Our Case Number: ABP-314724-22

Re: Railway (Metrolink - Estuary to Charlemont via Dublin Airport) Order [2022]
Metrolink. Estuary through Swords, Dublin Airport, Ballymun, Glasnevin and City Centre to
Charlemont, Co. Dublin

Metrolink Oral Hearing Follow-up

GRIFFITH PARK STATION

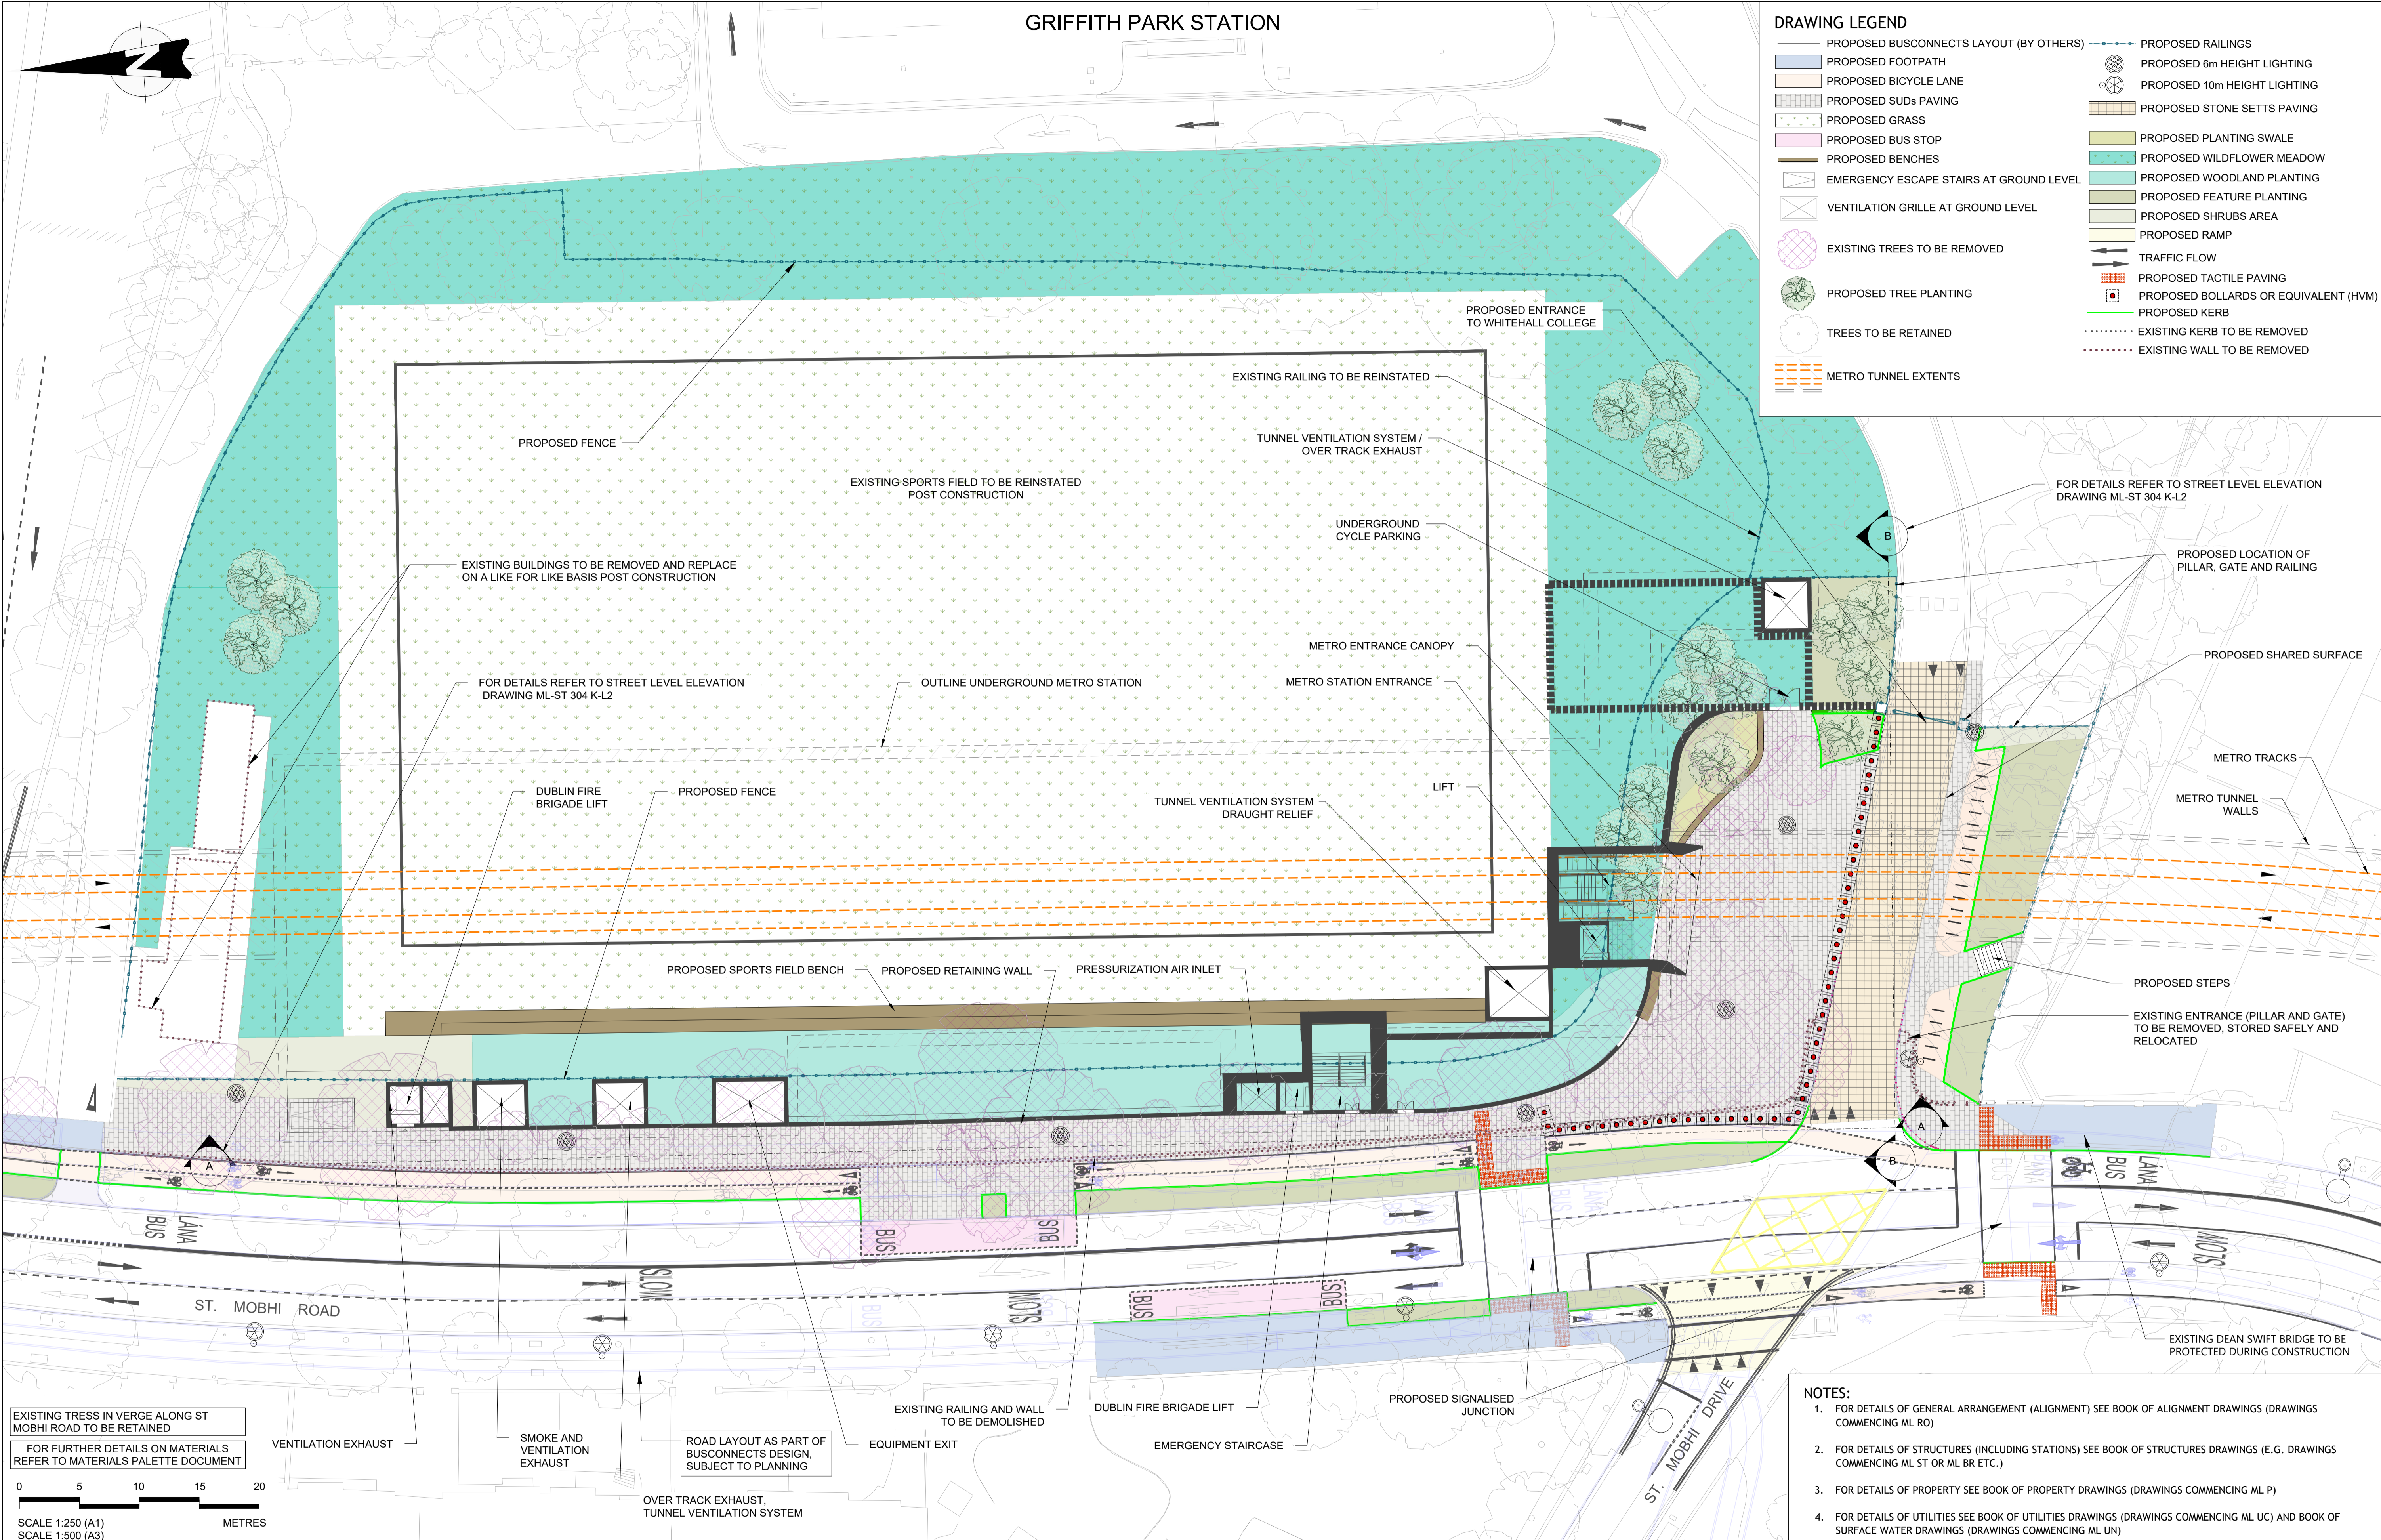
The underground cycle parking at the Griffith Park station could be two-tier cycle parking if the head height allows.

TARA STATION

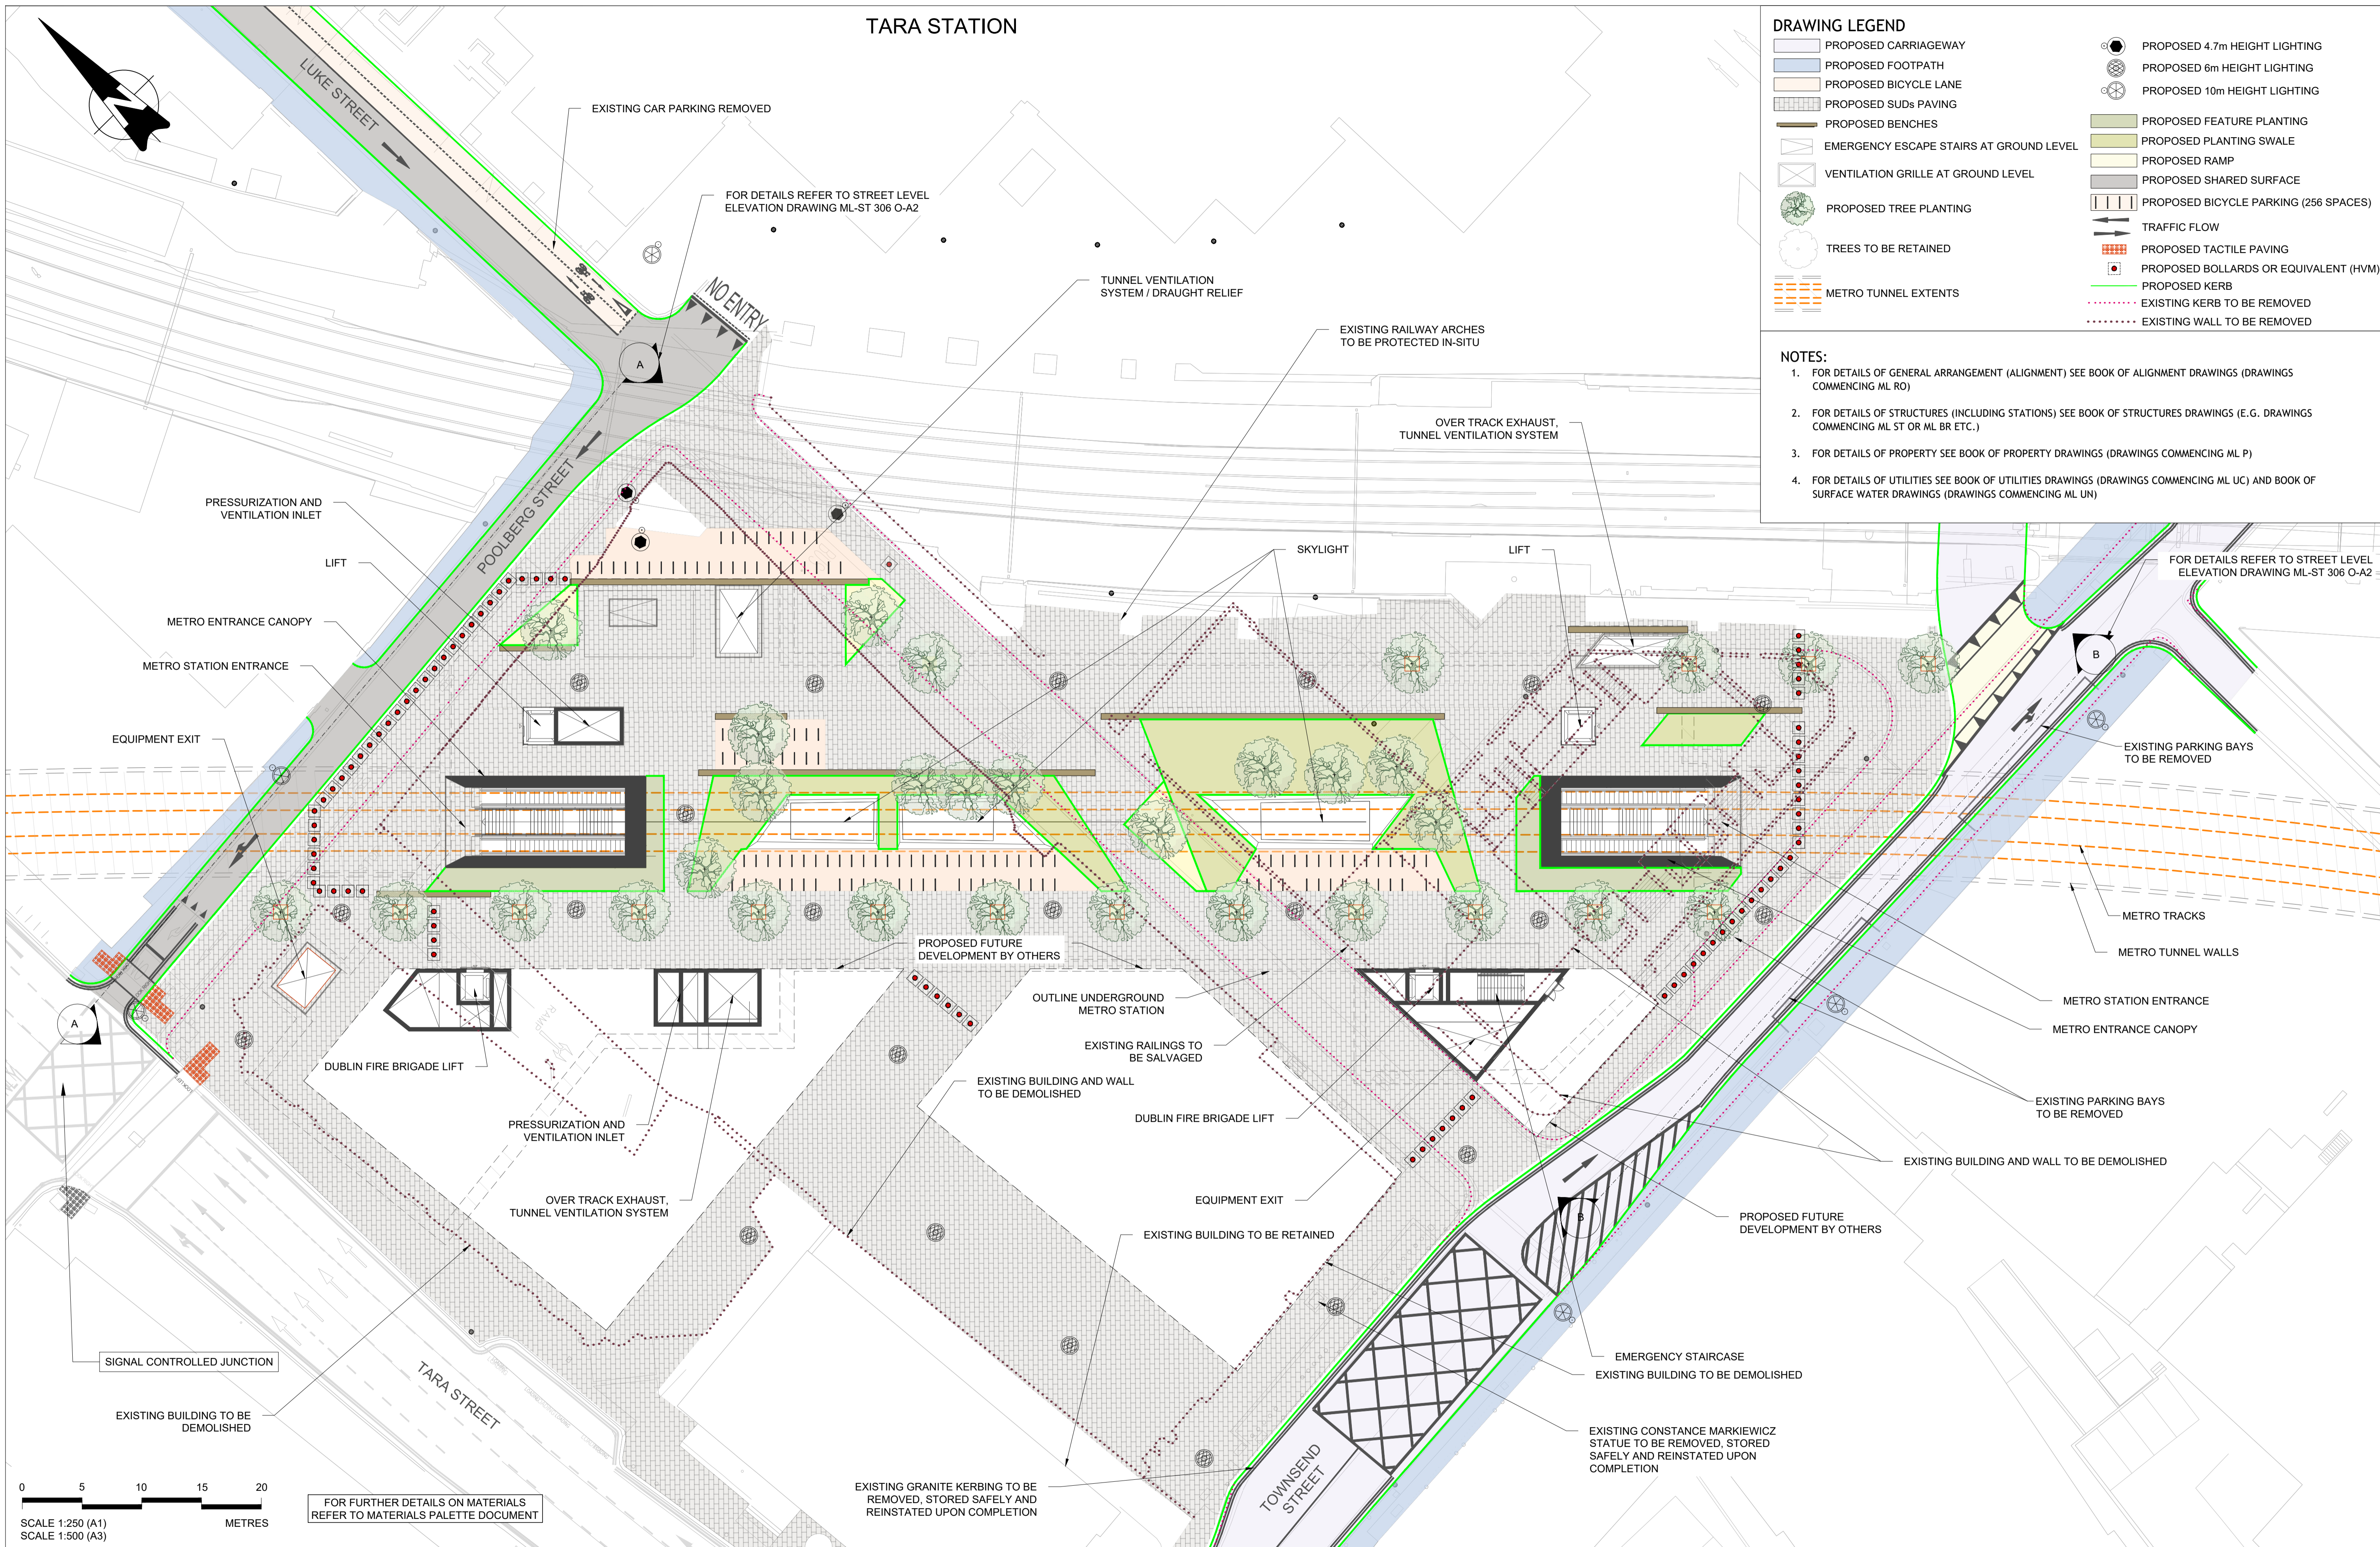
At the oral hearing we raised the questions around the TII controlled land surrounding the Tara metro station. But were provided no answer as to why this land wasn't used.

CHARLEMONT STATION

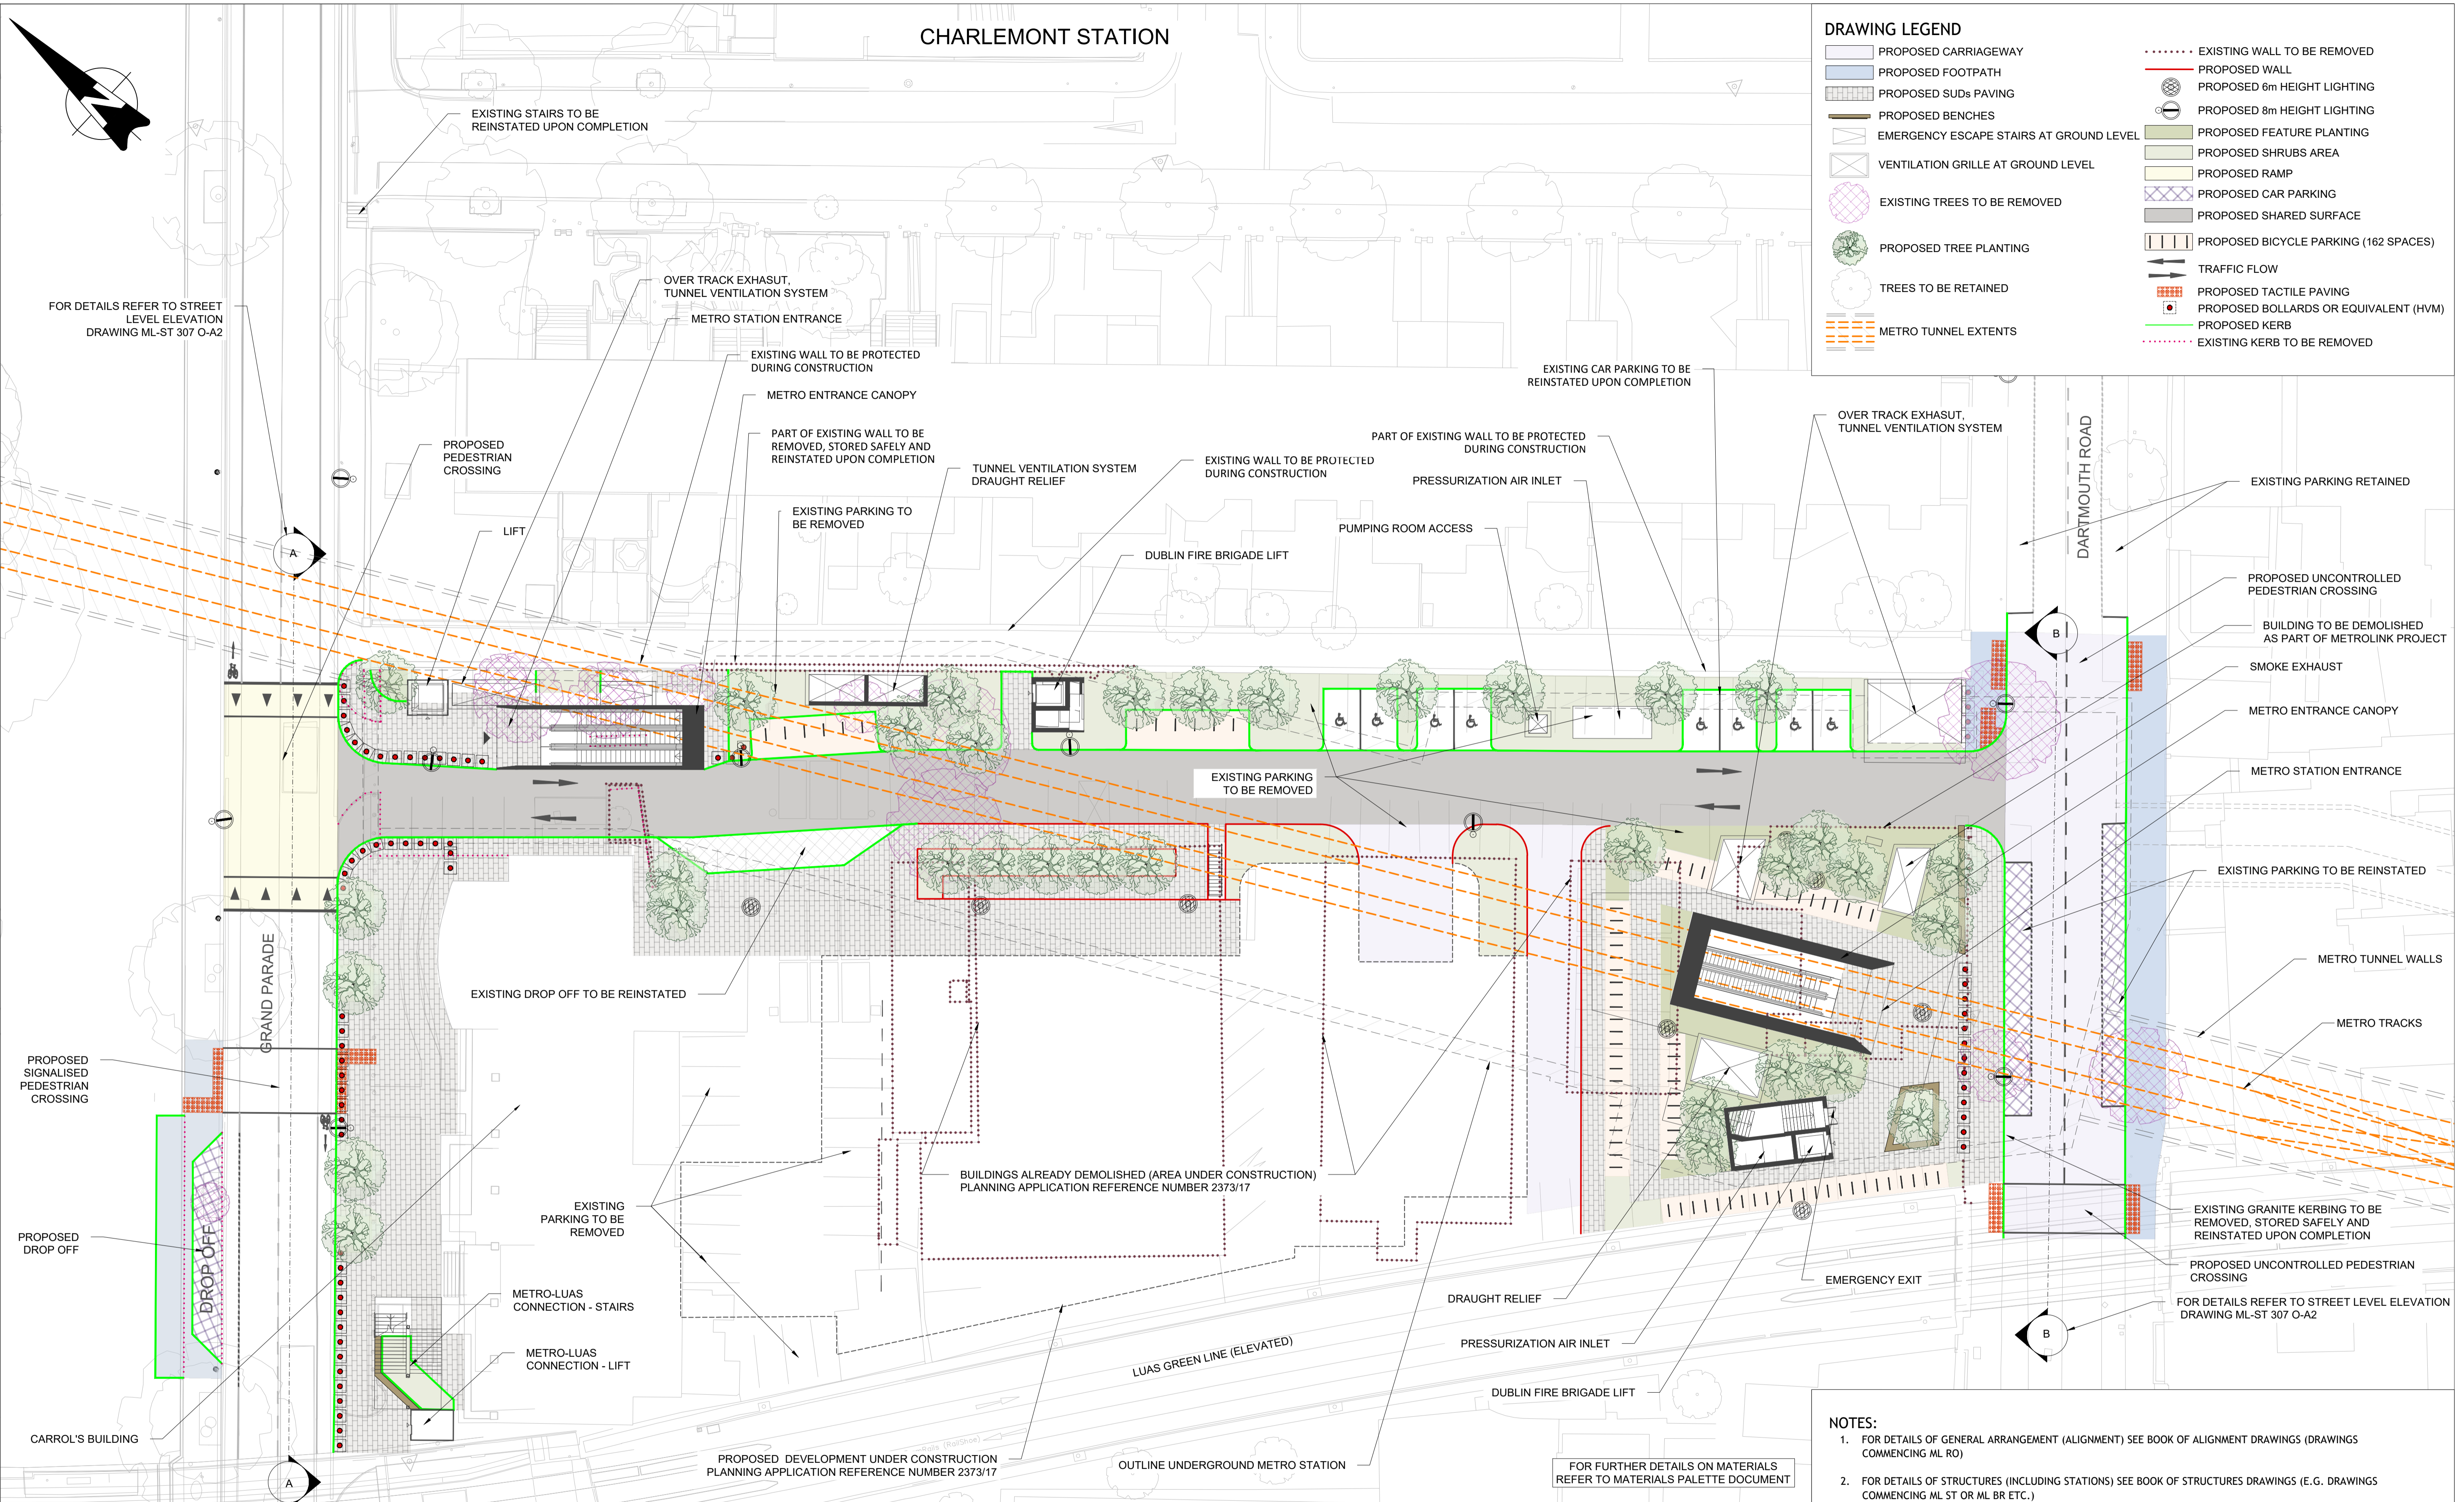
The only response at the oral hearing was that this would have a negative visual impact but that doesn't appear to have been assessed anywhere in the EIAR documentation. There are multiple places where two-tier cycle parking racks could have been used. For example, at the Charlemont station there is cycle parking along the Green Luas Line embankment that could be two-tier cycle parking with negligible impact.
